**Planning Act 2008 – Section 88 and the Infrastructure Planning (Examination Procedure) Rules 2010 – Deadline 3: Comments on Coastal Geomorphology Reports**

**Application by NNB Generation Company (SZC) Limited for an Order Granting Development Consent for the Sizewell C Project**

## Appendix A: Environment Agency comments on Coastal Geomorphology Reports

Figure 6: Topographic maps of the current and proposed SCDF topography.

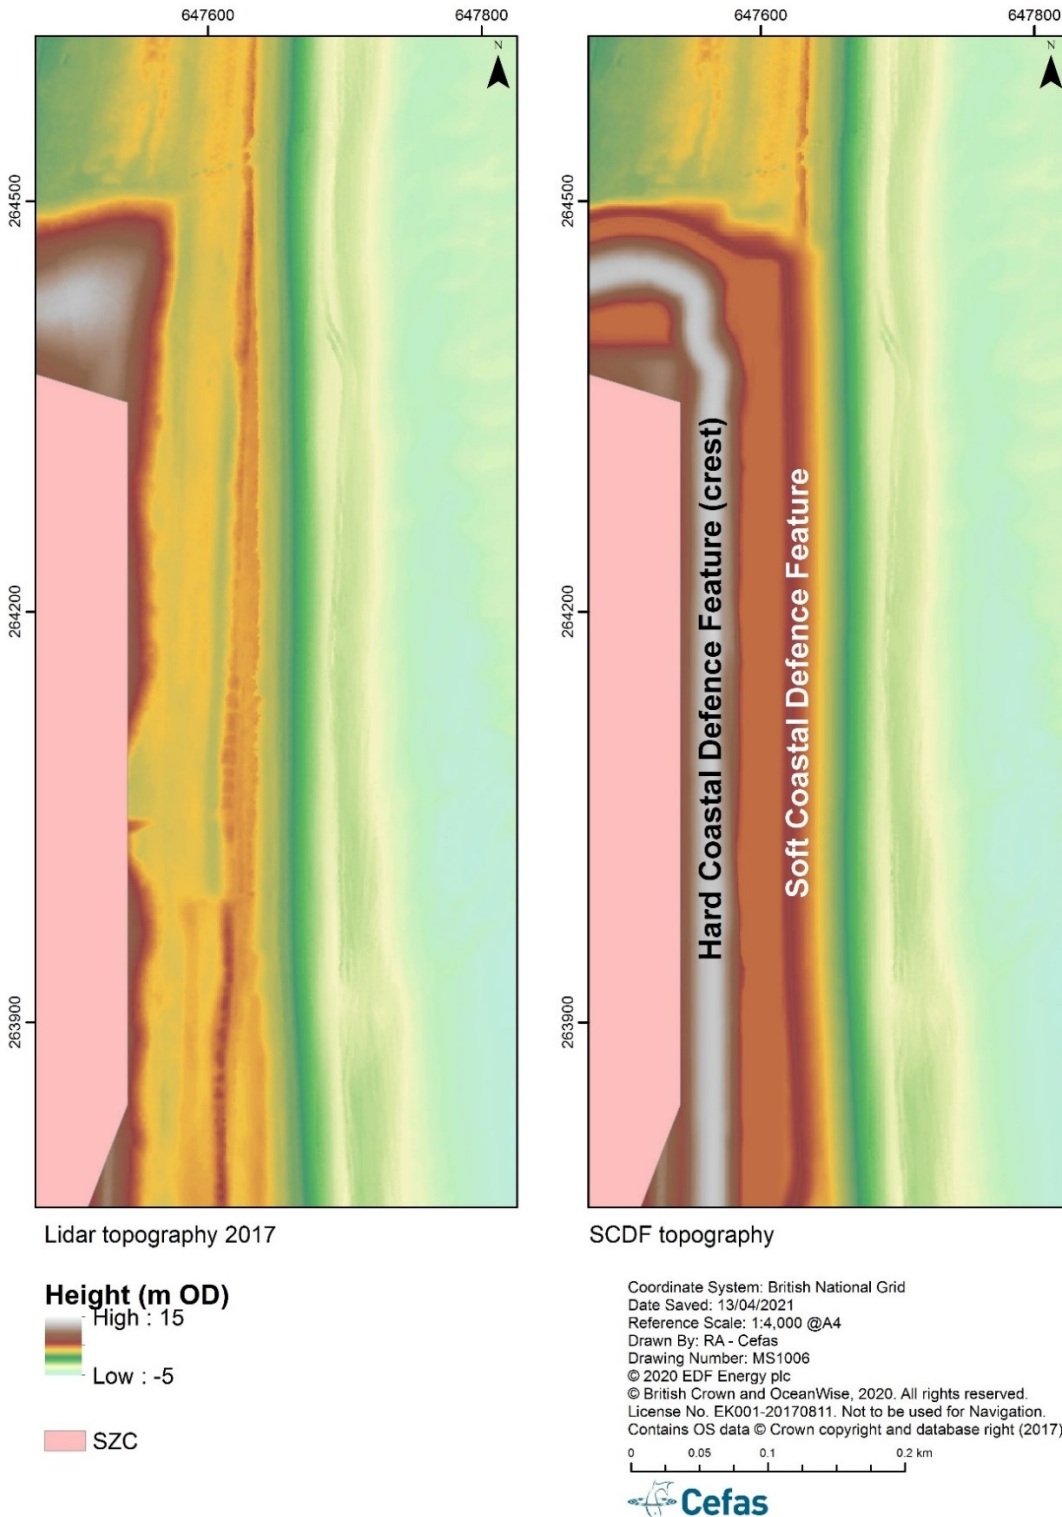
increase in recharge activities in order to protect the integrity of both SCDF and HCDF.	
2. SCDF Design	The Sizewell C Sea Defence Design Report outlines a planned design featuring a reorientation of the SCDF inland at the SCZ – SZB interface (e.g. see Figure 3-6 in that report). It is not clear whether this design – and any resulting geomorphological implications (e.g. concerning shingle transport or wave refraction) have been considered in TR544, or whether this will be considered in TR545. Are the current defences of SZA/B of a sufficient level/height to perform the job of protecting SZC from outflanking to the south?	Analysis is required of potential geomorphological implications of the proposed design for the SCDF at the interface with Sizewell B.

Figure 14 The loss of sediment volume from the BfE storm in 2099 with receded lateral shorelines (left) and the remaining sediment volume of the SCDF after the BfE storm (right).

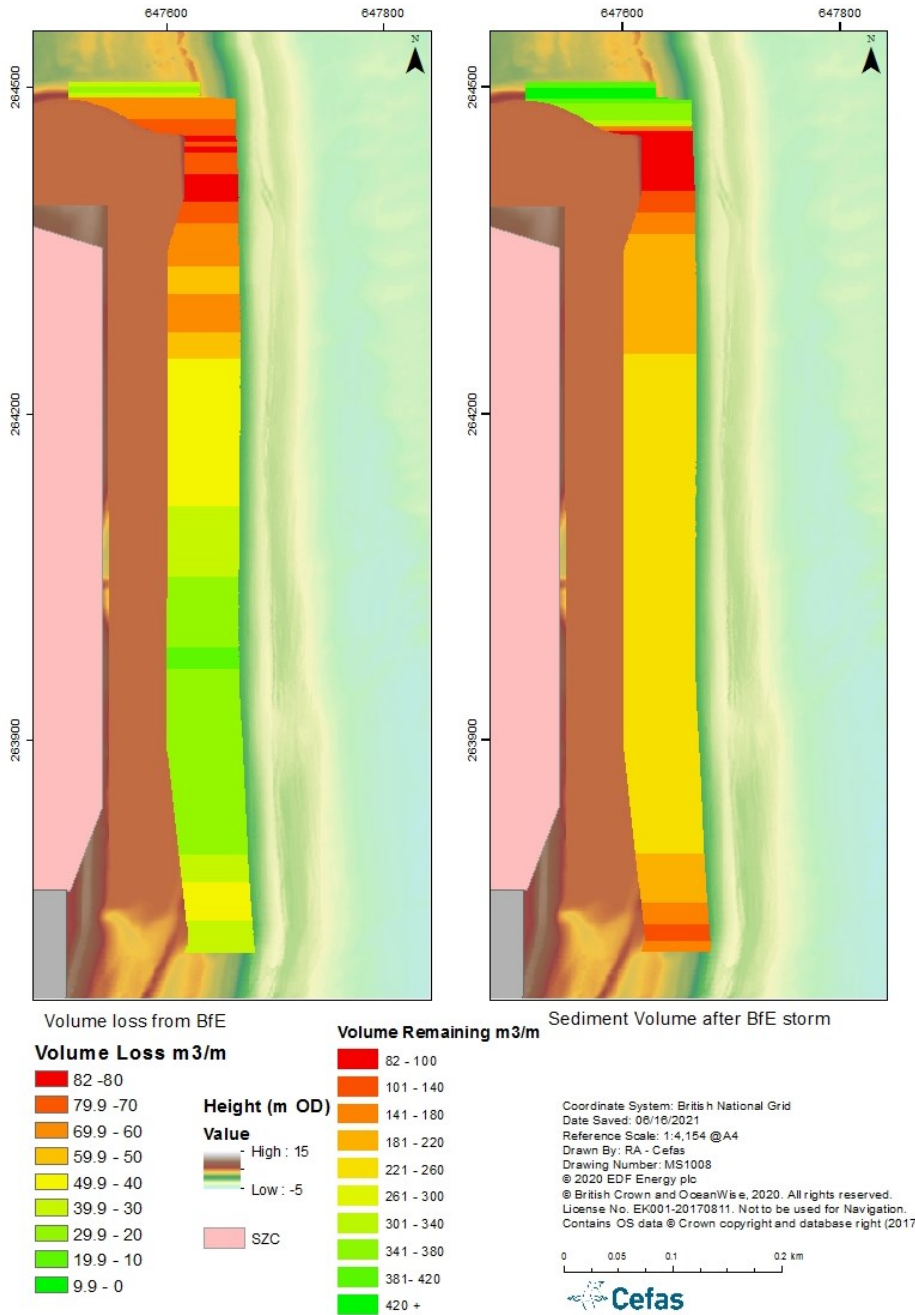
2.3.1, p.20	We welcome the planned addition of modelling to account for more severe storms, erosion of neighbouring shoreline and higher sea levels planned for TR545. We would ideally like to see some (or preferably all) of the concerns outlined in this document and the comments on TR531 addressed in TR545 alongside these additional factors.
